WEST SUSSEX COUNTY COUNCIL CONSULTATION

TO:	Arun District Council FAO: Simon Davies
FROM:	WSCC - Highways Authority
DATE:	22 January 2020
LOCATION:	The Cottage Shripney Road Bognor Regis PO22 9PA
SUBJECT:	BE/137/19/RES Application for approval of phase 2 reserved matters following outline permission BE/63/17/OUT (as amended by BE/131/18/PL) for 20 No. dwellings.
DATE OF SITE VISIT:	n/a
RECOMMENDATION:	More Information
S106 CONTRIBUTION TOTAL:	n/a

6.06 Plot 17-20

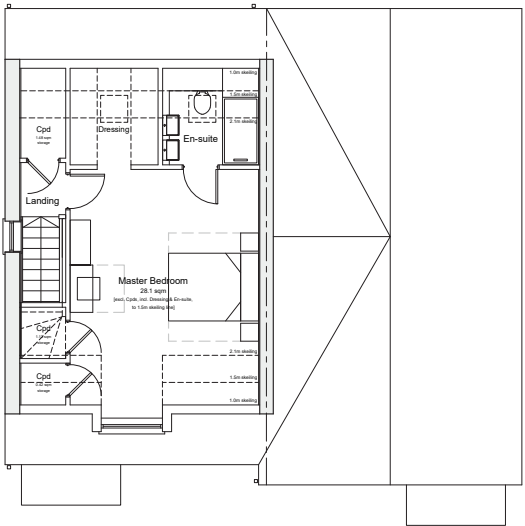
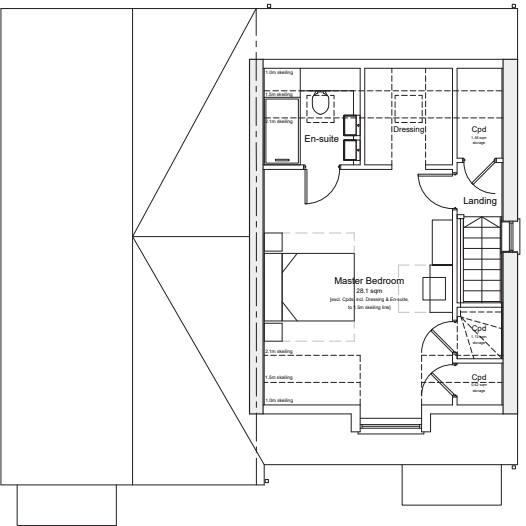
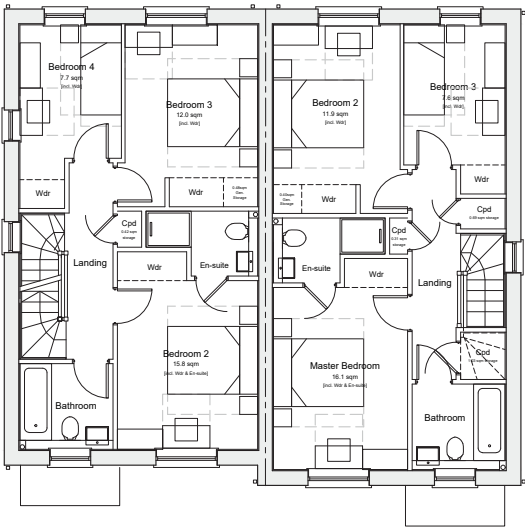
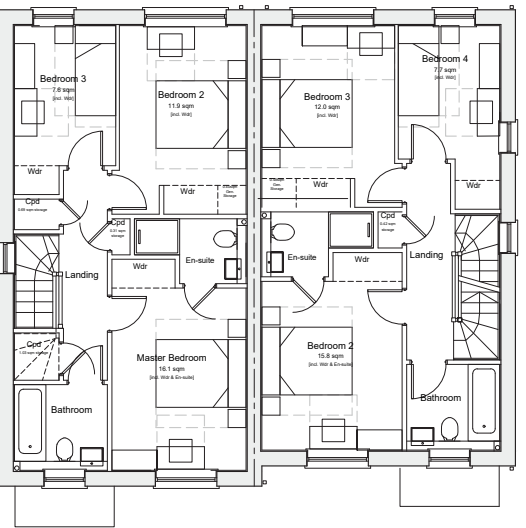
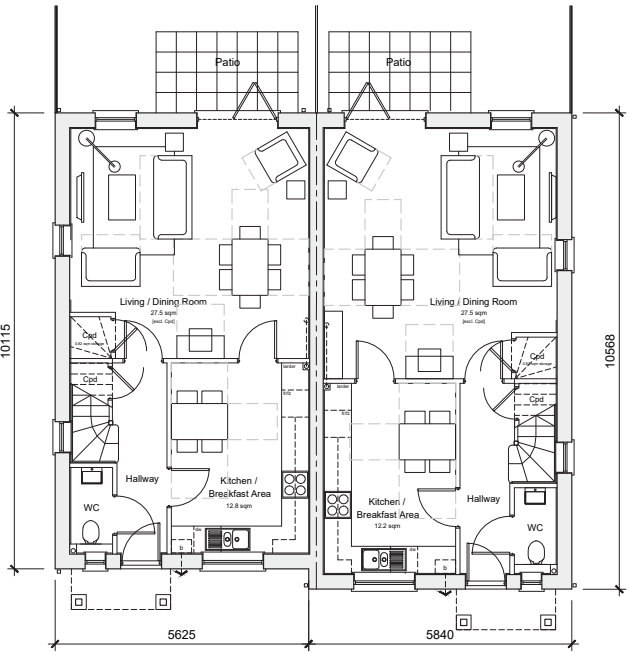
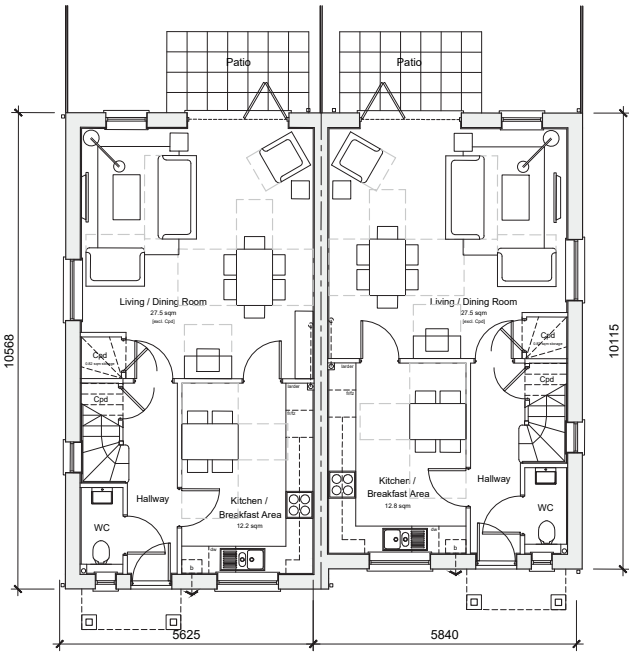
Whilst a consequence of the design, the visitor parking spaces north of 20 will potentially be more convenient for those residents of plots 17-20 as opposed to using the allocated spaces to the rear of these plots. Should this occur, the availability of visitor parking would be greatly reduced with only two spaces (both of which are within the car park for plots 1-6) then available. Measures (e.g. timed restrictions) should be shown to control the use of these spaces as well as lighting on the footpath leading from the car parking area.

Drawing 160818-TK04

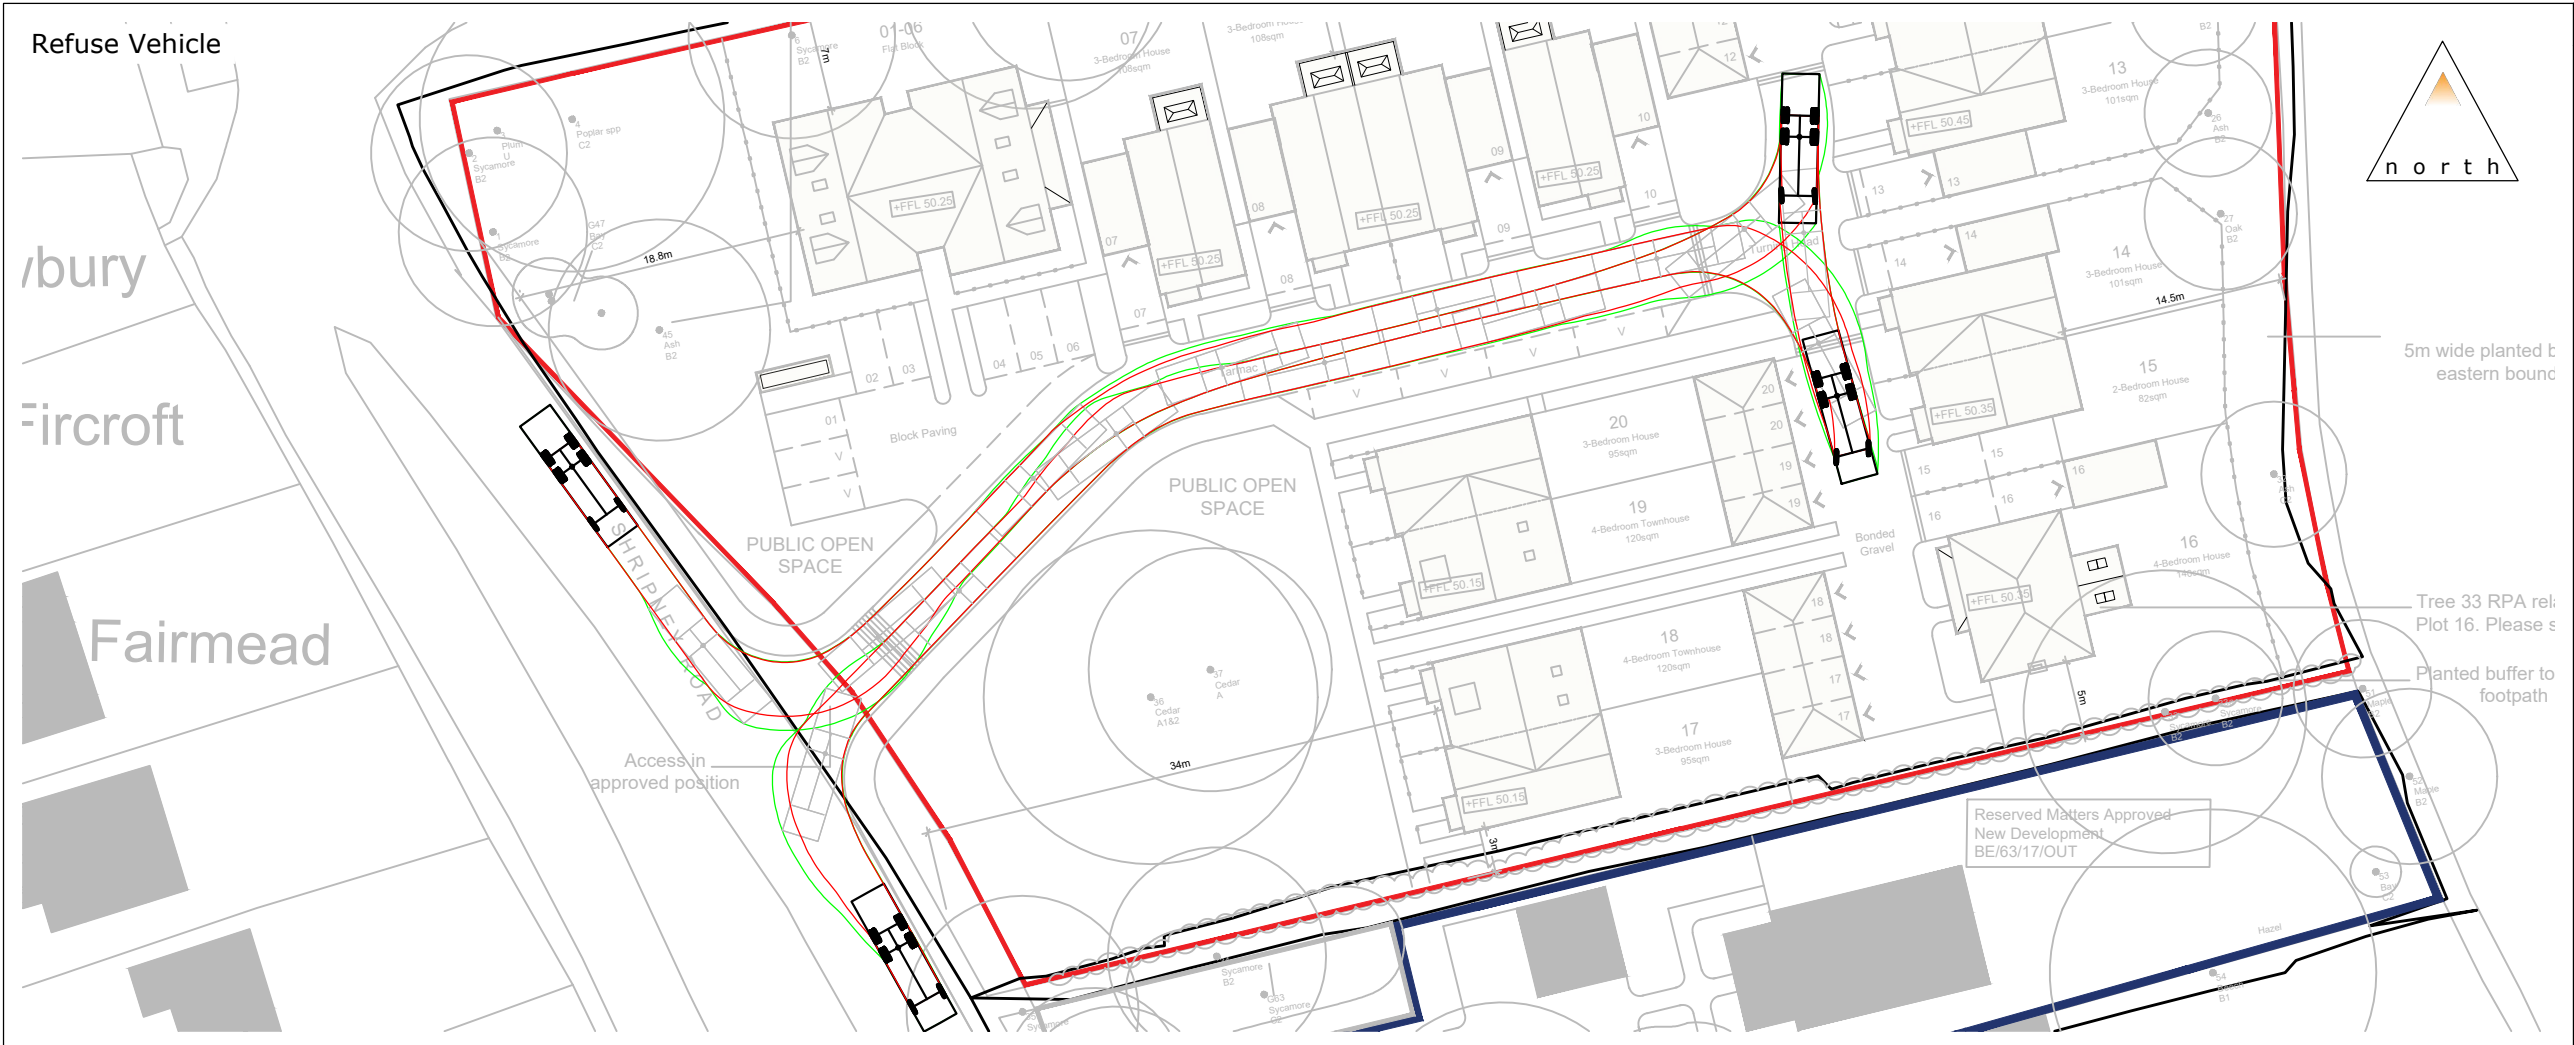
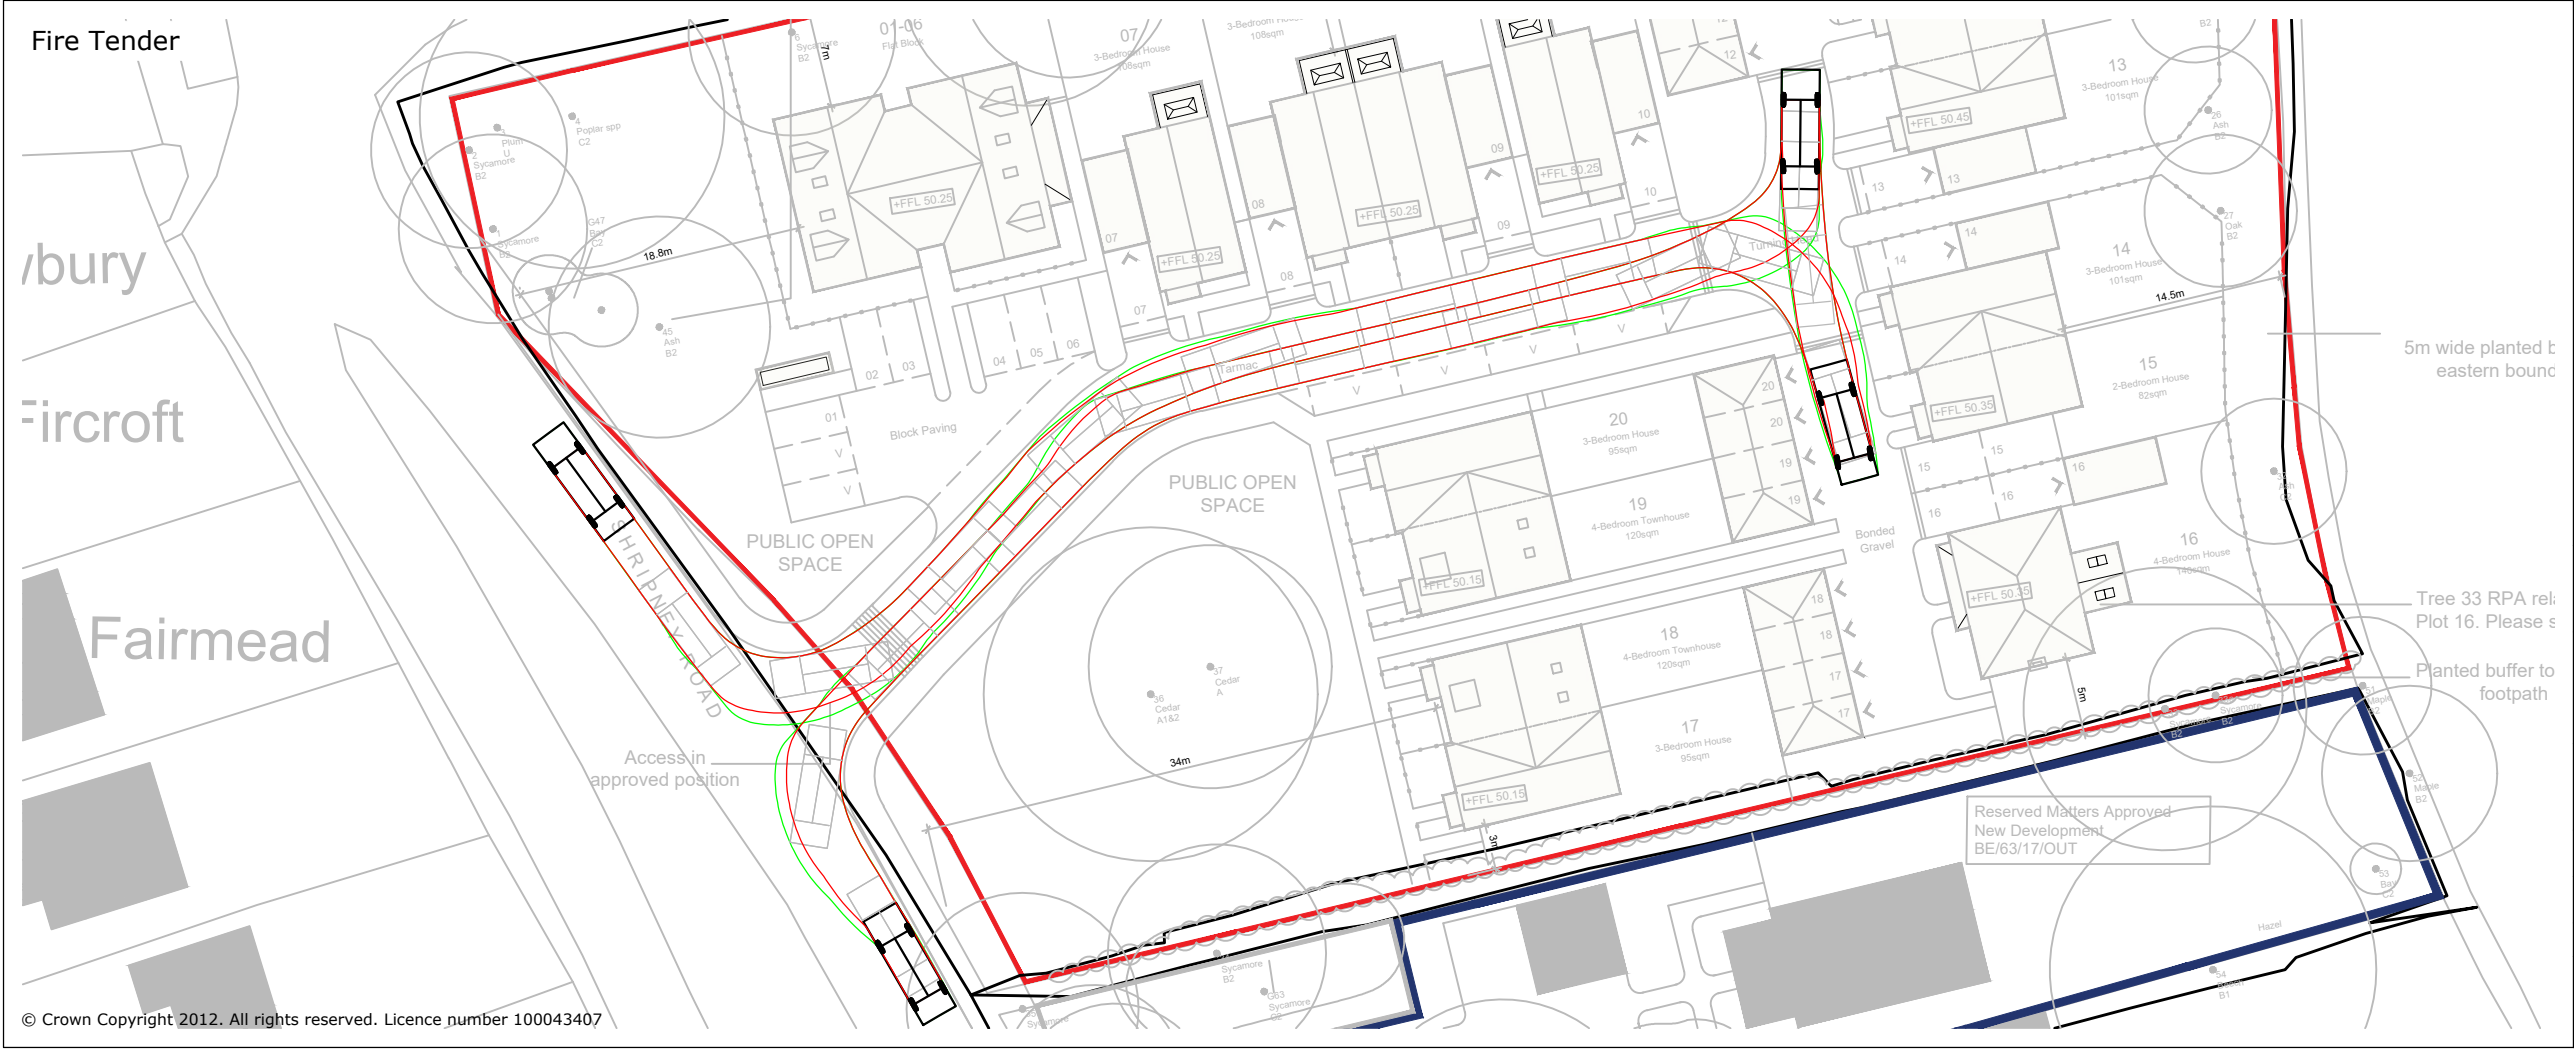
Tracking is demonstrated for a 9.86 metre refuse vehicle. Although no over-running is indicated, the tracking is very tight to the kerb with very little margin for error. This aside, it must be confirmed with the Arun DC waste

collection team that the correct vehicle dimensions have been applied and that the collection arrangements are acceptable. In practice and based on the tracking as shown, there would be logic in increasing the road width (currently at 4.5 metres) into the adjoining parking courts. In the event a refuse vehicle cannot turn on-site, this would inevitably then result in reversing manoeuvres onto or off of the A29. Such a manoeuvre would not be supported by WSCC Highways.
